Application No: SSD 13_6123

Campus Improvement Program 2014-2020 for Camperdown-Darlington

RAIDD Response to RtS for SSD6123

Name: RAIDD (Residents Acting In Darlington's Defence)

01 ENGINEERING - SHEPHERD STREET ELEVATION PROPOSED

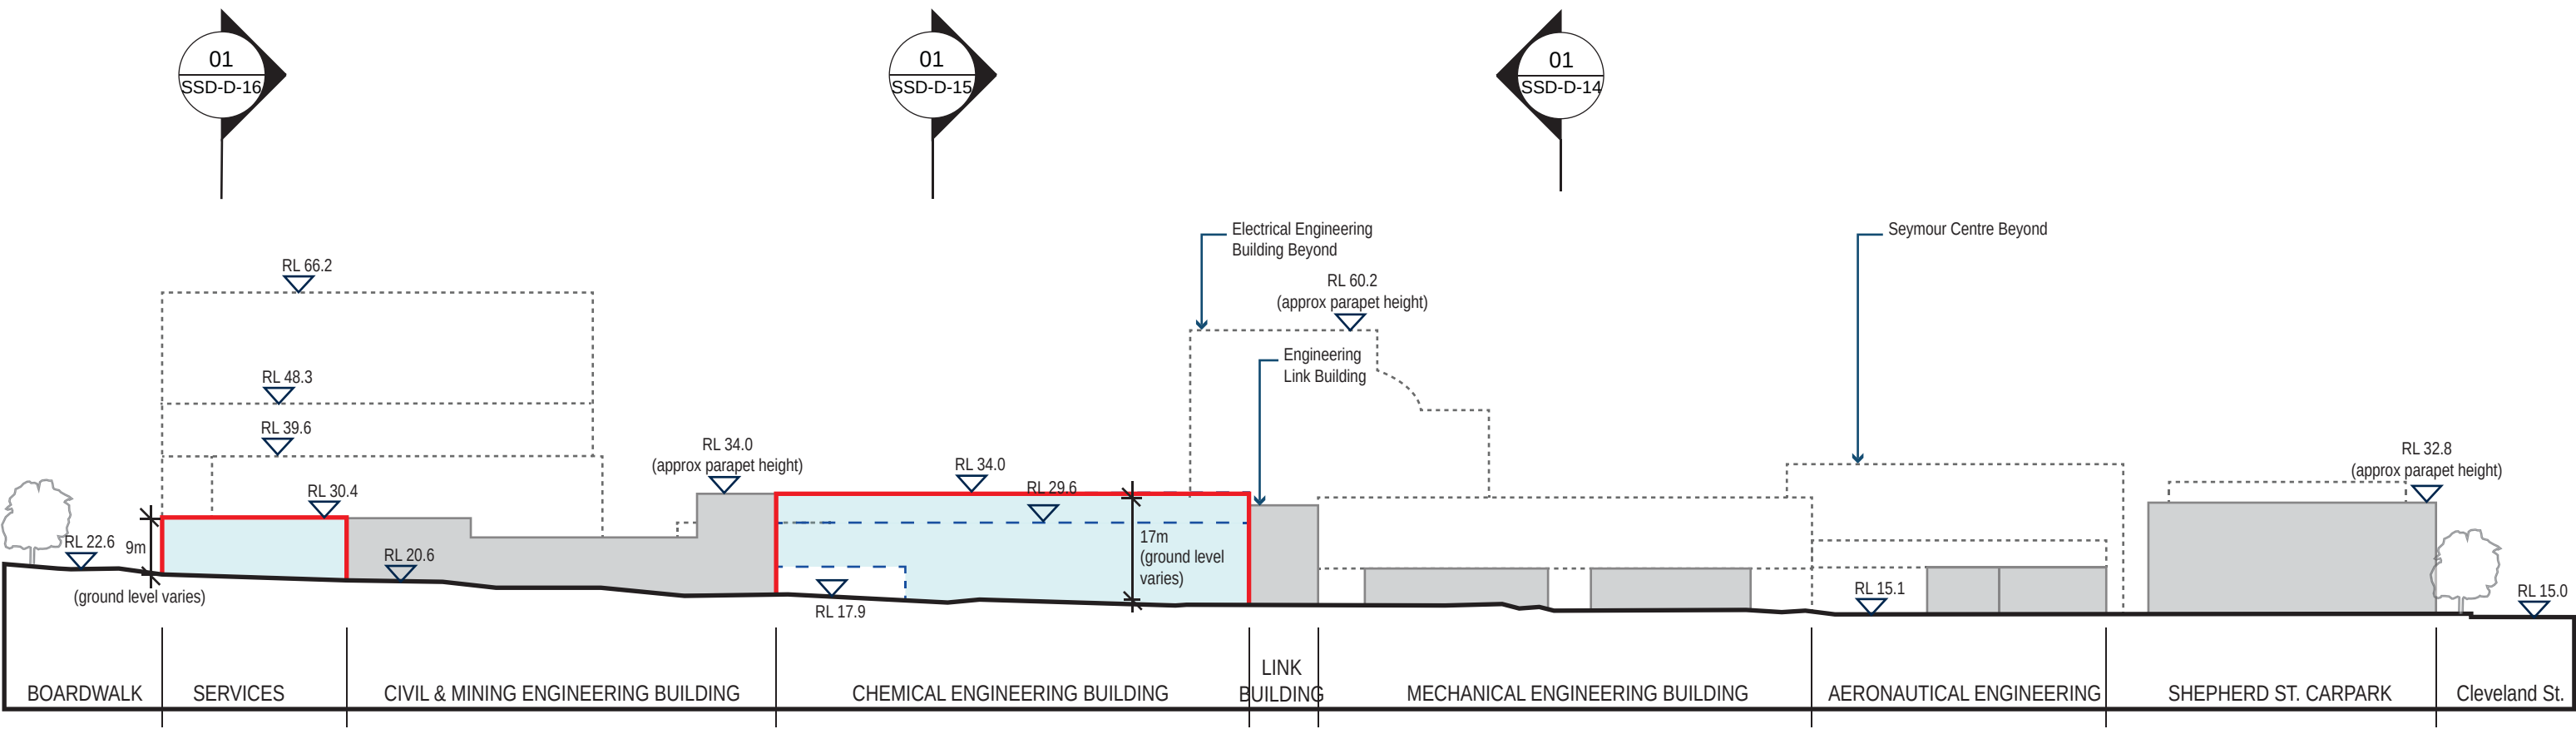
We remain opposed to the proposed Service Centre on Shepherd Street. We understand the rationale behind having principal Service Centres but repeat our suggestion that a more appropriate location for it would be near the intersection of Shepherd and Cleveland Streets.

This would mean the heavy service vehicles could enter and exit from the main arterial road of Cleveland Street and would therefore be kept off residential streets.

01 DARLINGTON TERRACES - PROPOSED ENVELOPE PLAN

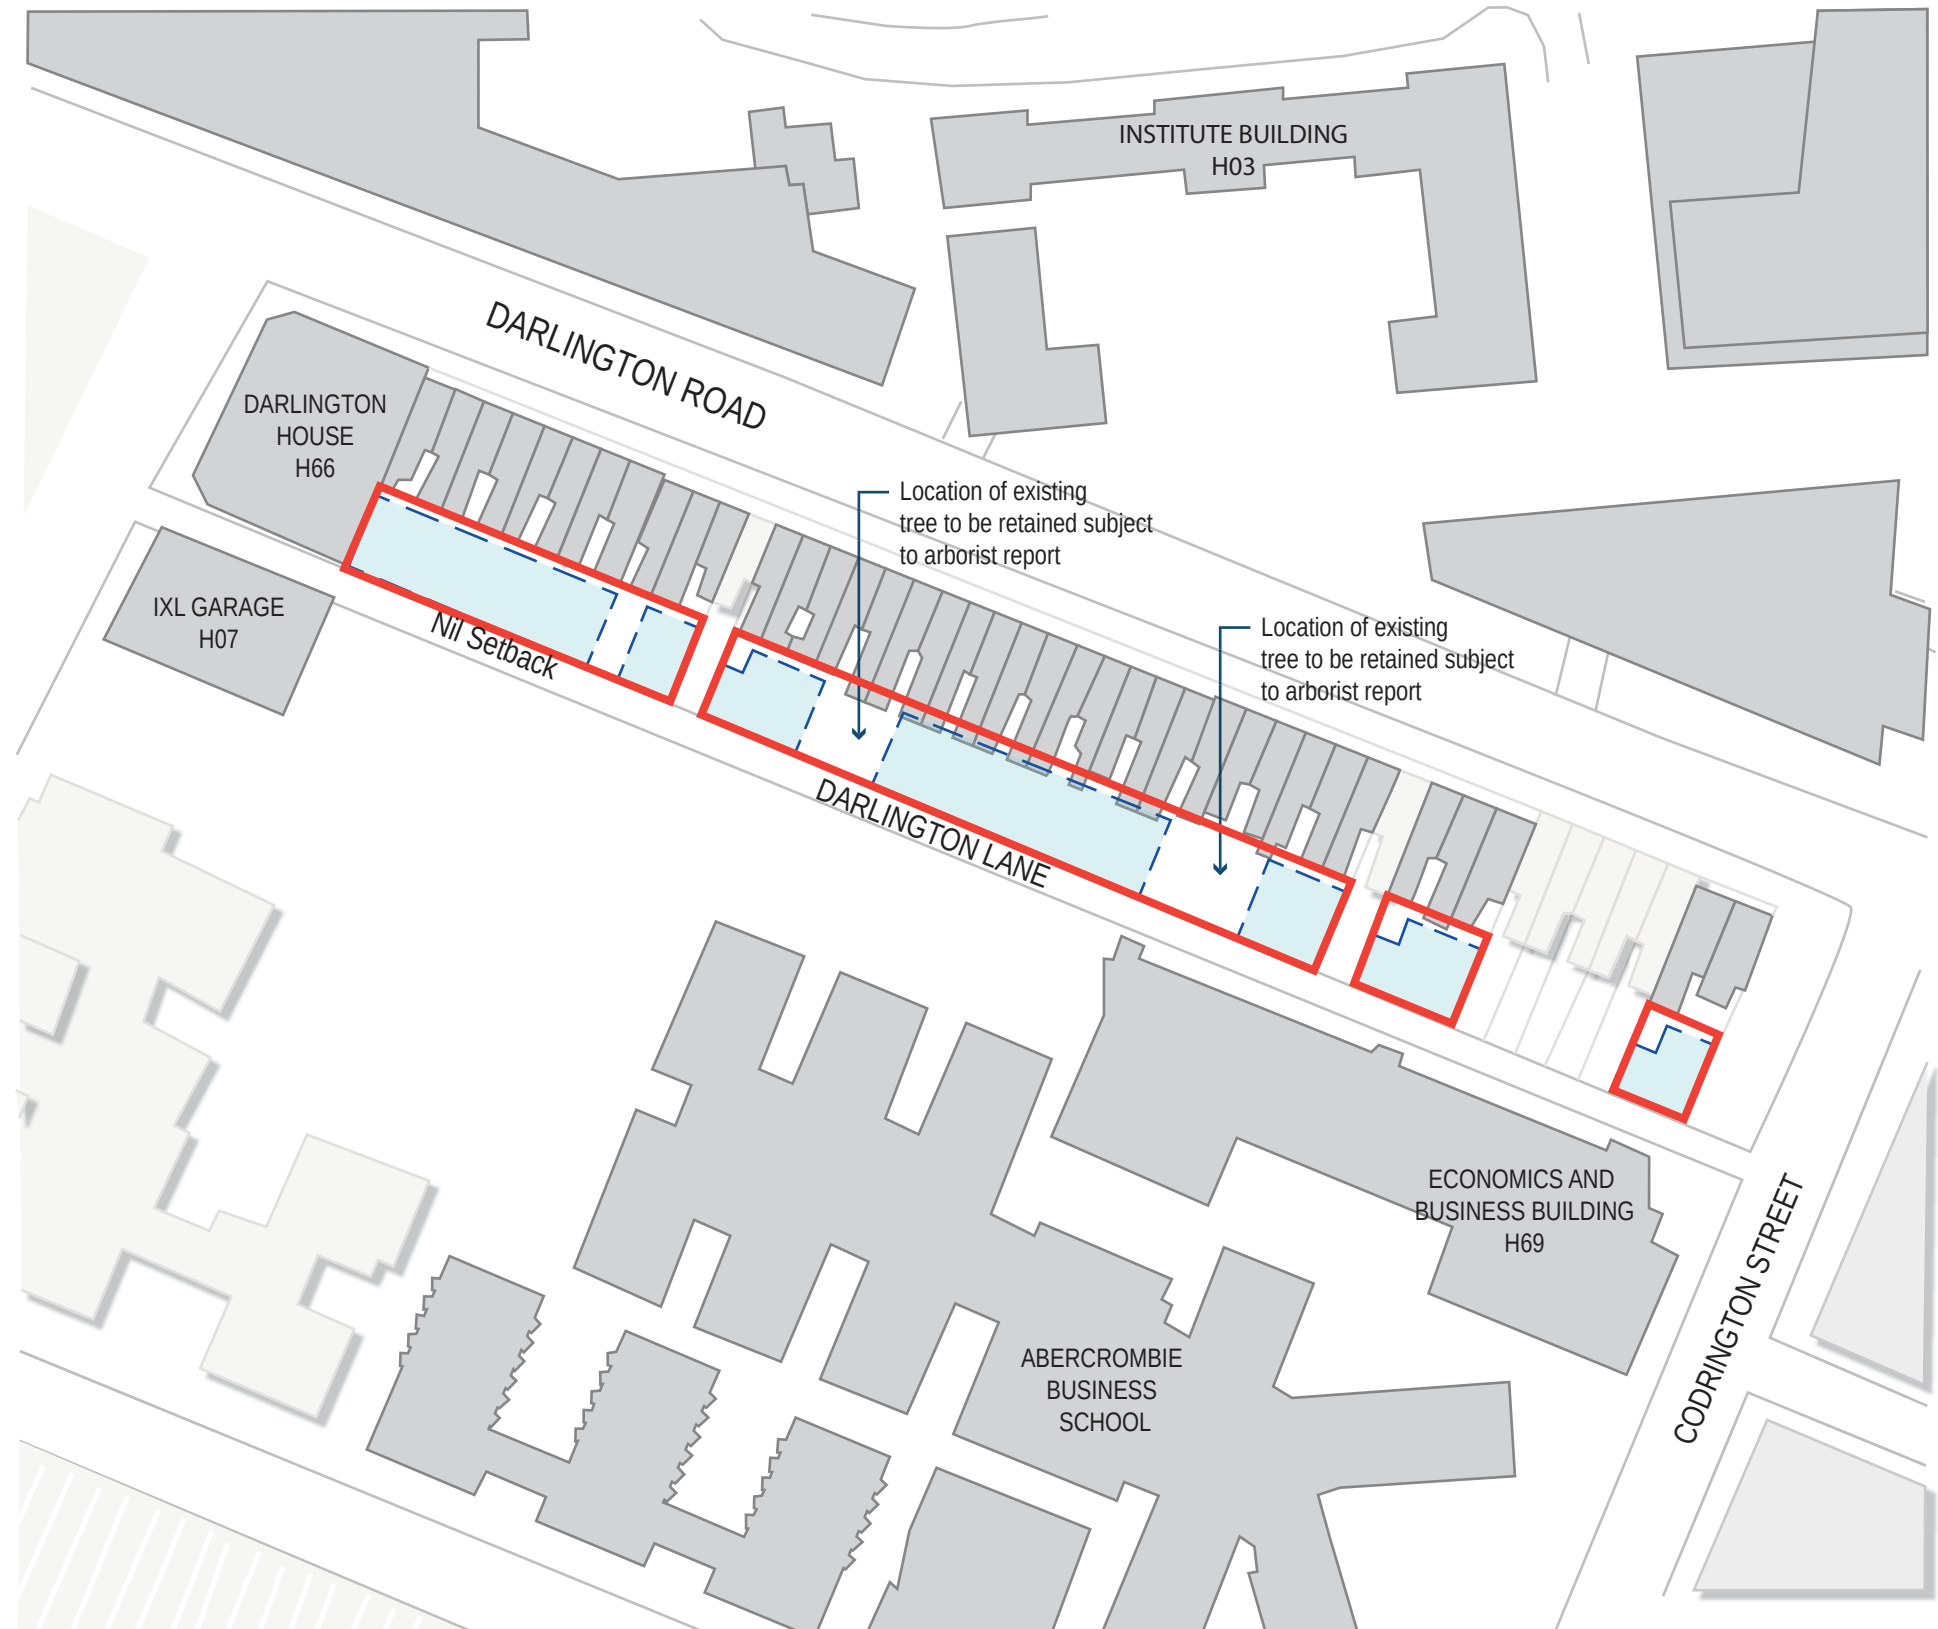
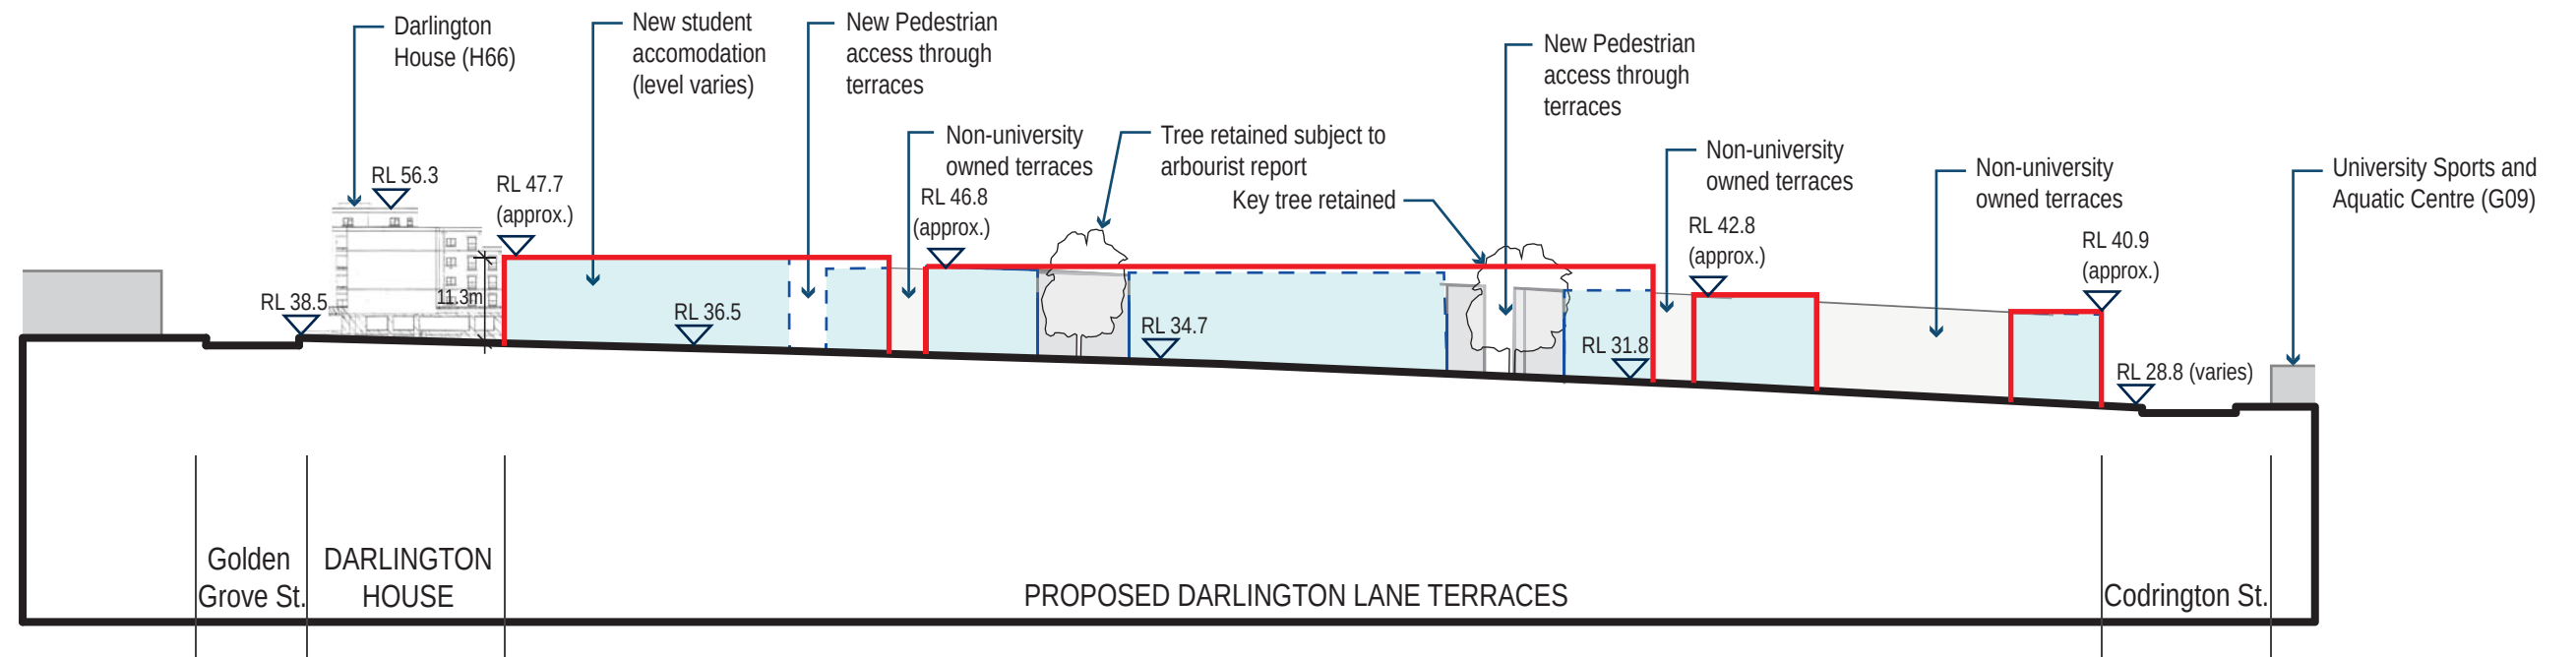
We vehemently object to the University's proposal to completely infill the backyards of every heritage listed terrace house (bar 3) from 86 – 130 Darlington Road with 3 storey extensions. The University will have used almost every piece of land for building on leaving very little open space, vegetation or light which are all important to the health and wellbeing of humans.

The National Trust has given these terraces an "A" rating – "highly intact". The University should not be allowed to degrade the heritage value of these terraces which are very close to the Golden Grove.
